Consultation Response from: KC Environmental Health (Pollution & Noise Control)

2024/91954 13 Westgate, Cleckheaton, BD19 5ET

Change of use of basement into self-contained flat and erection of dormer windows at second floor

**Responding Date:
5th September 2024**

PROPOSED BASEMENT FLOOR

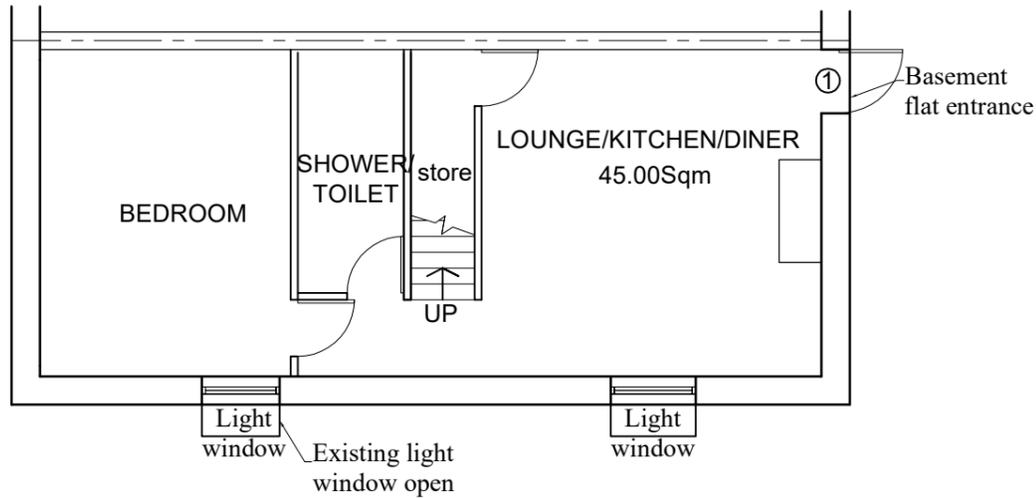
We have reviewed the application and supporting information, we offer the following comments. The application concerns the repurposing of the existing basement area to provide self-contained residential accommodation.

Noise from customers and commercial activities in the shop above the proposed development may give rise to loss of amenity to future residents. In order to protect future residents from noise associated with the commercial shop above we recommend a condition to secure appropriate insulation.

Before the development is brought into use written evidence to demonstrate that the airborne sound insulation performance of the party structures of the development is of a minimum of 55dB $D_{nTw} + C_{tr}$ shall be submitted to and approved in writing by the Local Planning Authority. If it cannot be demonstrated that the aforementioned airborne sound insulation performance has been achieved, a scheme incorporating further measures to achieve the sound insulation performance shall be submitted to and approved in writing by the Local Planning Authority. All works comprised within those further measures shall be completed and further written evidence to demonstrate that the aforementioned sound insulation performance level has been achieved shall be submitted to and approved in writing by the Local Planning Authority before the development is first brought into use.
